Reference: 218990  
Department Reference: SSD 9670 MOD1

**RE: RESPONSE TO REQUEST FOR ADDITIONAL INFORMATION  
WSU INNOVATION HUB – 2-6 HASSALL STREET, PARRAMATTA (SSD 9670 MOD1)**

Ethos Urban write on behalf of Western Sydney University, in response to your letter requesting additional information dated 3 February 2020. This letter provides a response and a formal request to modify condition B23 in relation to the stormwater management system, as part of MOD 1.

STORMWATER CONCEPT PLAN

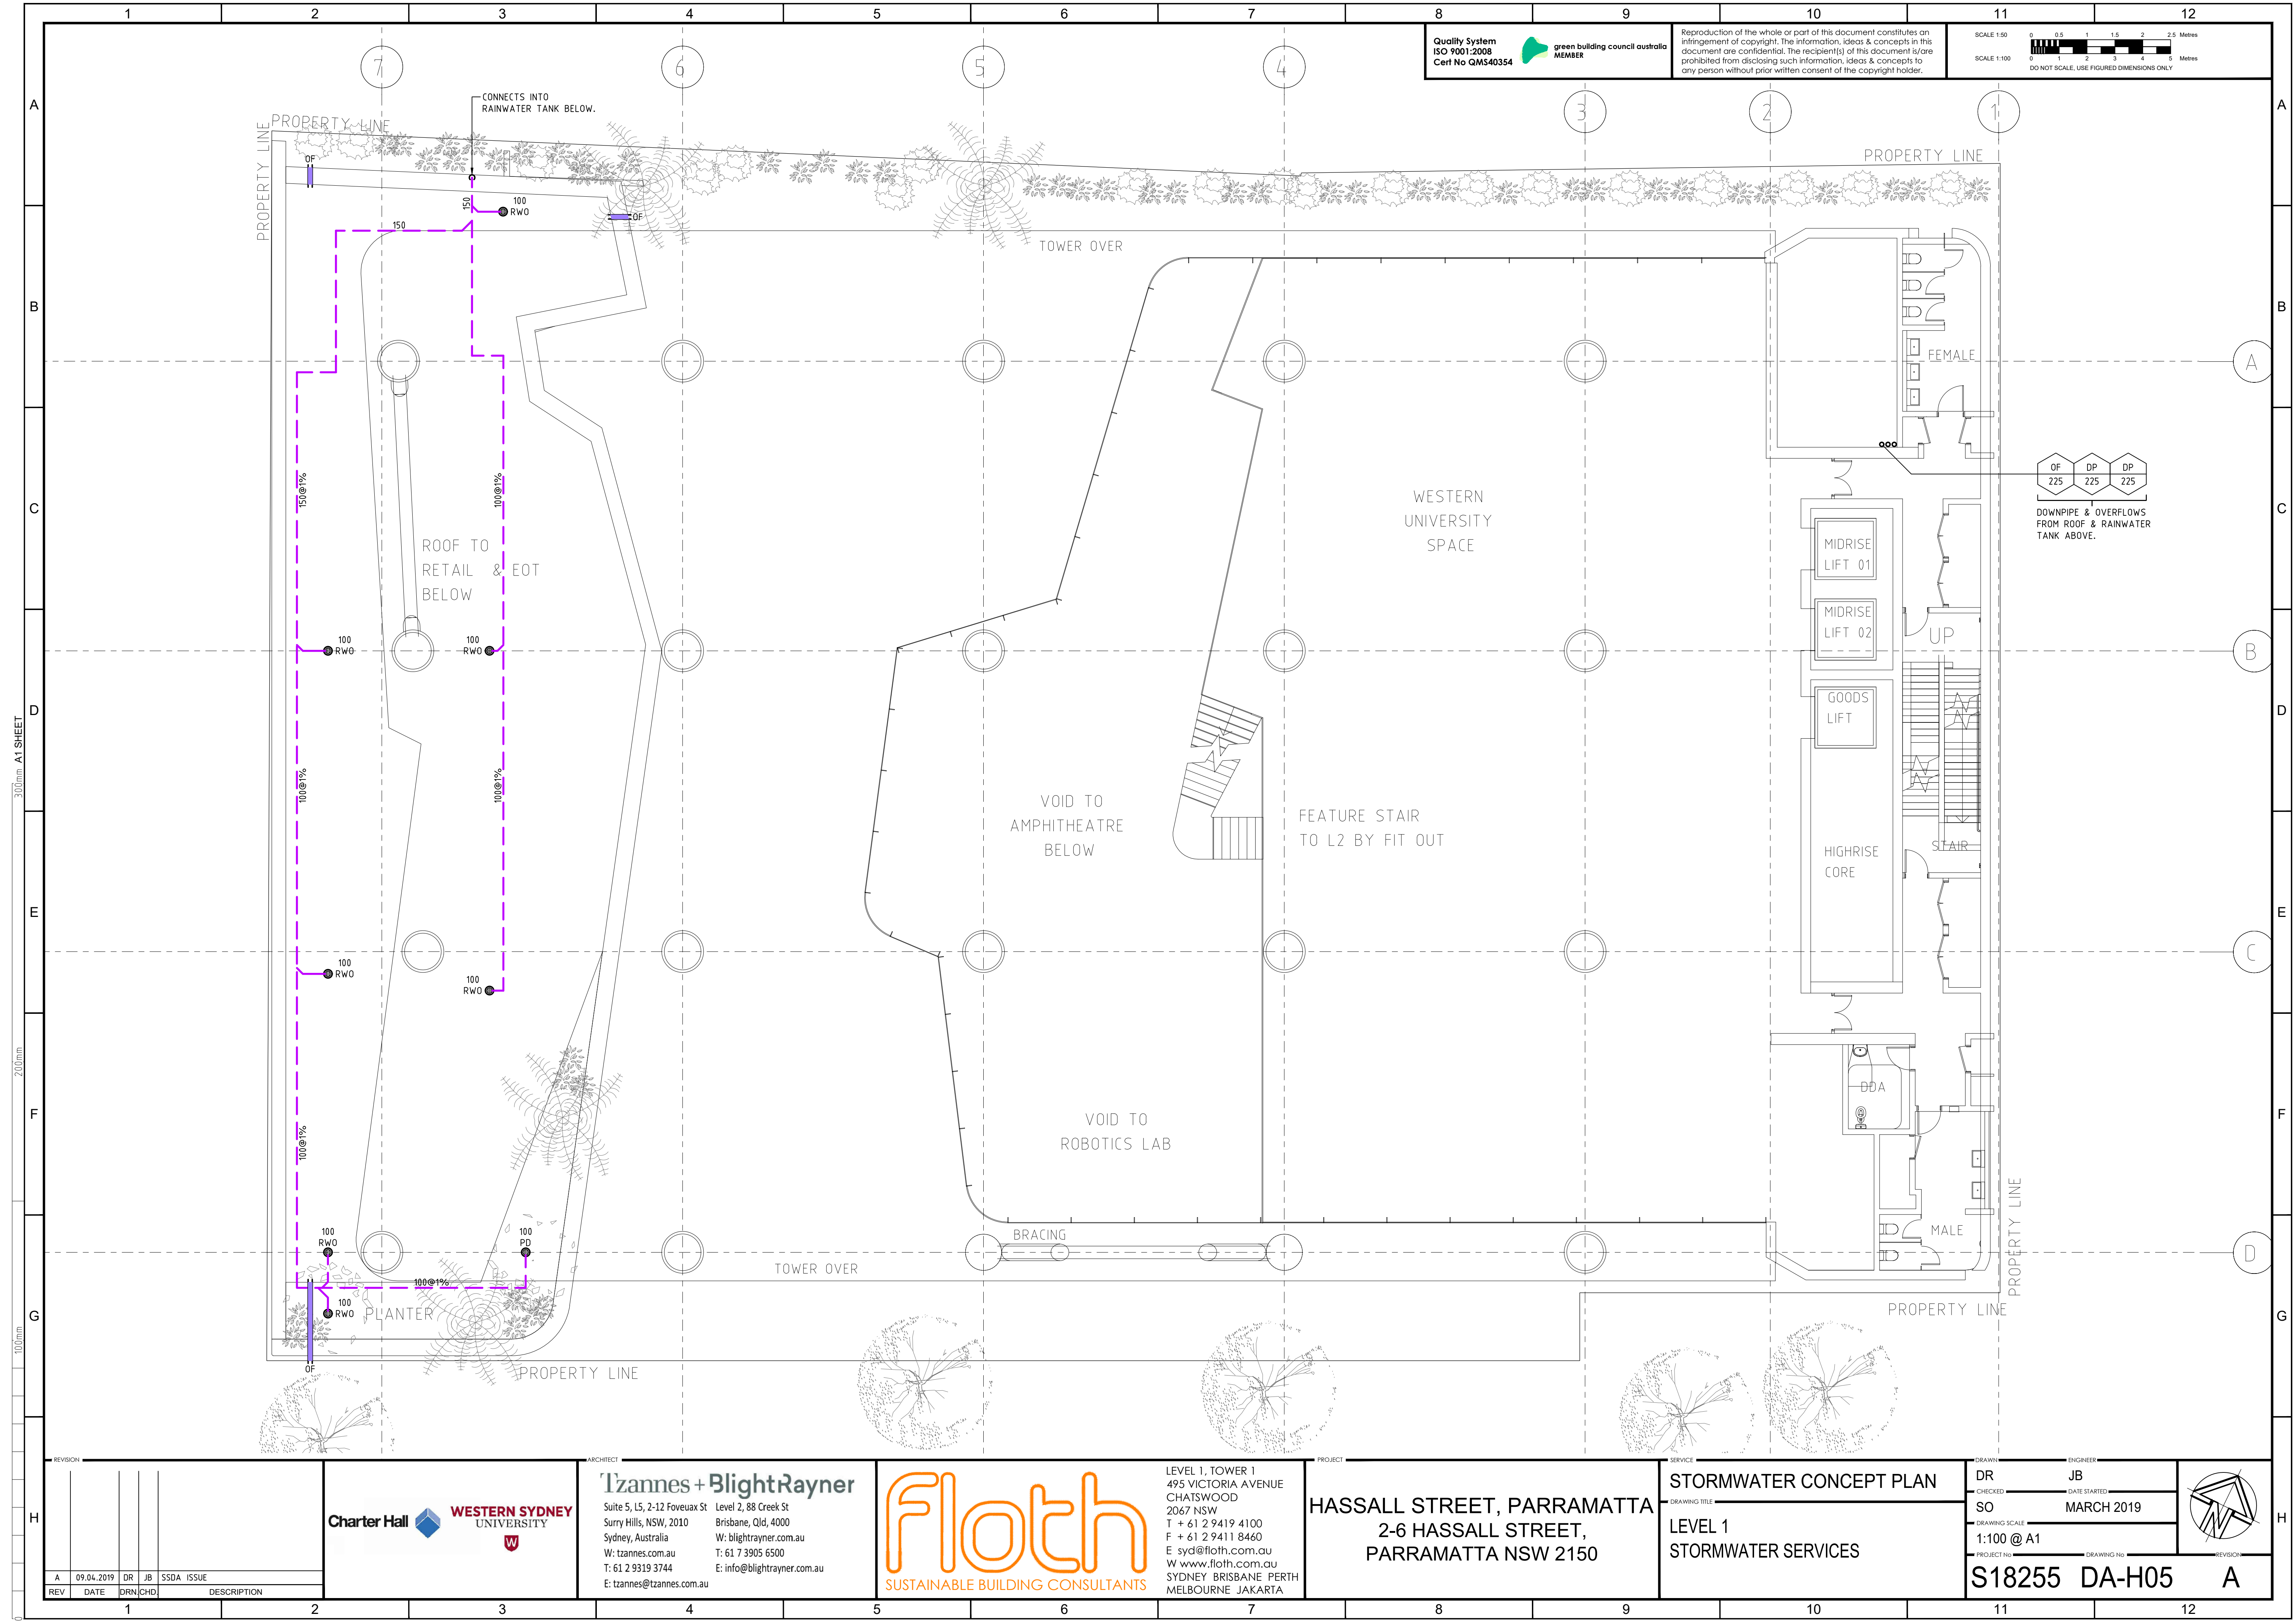
The western stormwater option does not include kerb inlets and does not directly follow the kerbline for the whole length. The proposed amended wording reflect this difference and keeps open the option to connect to the deeper pit at the southern side of Hassall Street (near Station Street) if technical requirements necessitate this arrangement.

- a) be designed by a suitably qualified and experienced person(s);
- b) include a stormwater drainage pipeline ~~with kerb inlet pits~~ along ~~the kerbline of~~ Hassall Street ***(with kerb inlet pits along the kerbline, if required)*** from the site ~~either westwards to the point of connection near the intersection of Hassall Street and Station Street or~~ eastwards then crossing Hassall Street to the point of connection near 13-15 Hassall Street, with minimum 375mm diameter concrete spigot and socket pipe in accordance with Council's standards with an underground connection from the site to the kerb inlet;
- c) be designed in accordance with On-site Detention and Water Sensitive Urban Design requirements in Parramatta Development Control Plan 2011;
- d) be in accordance with applicable Australian Standards;
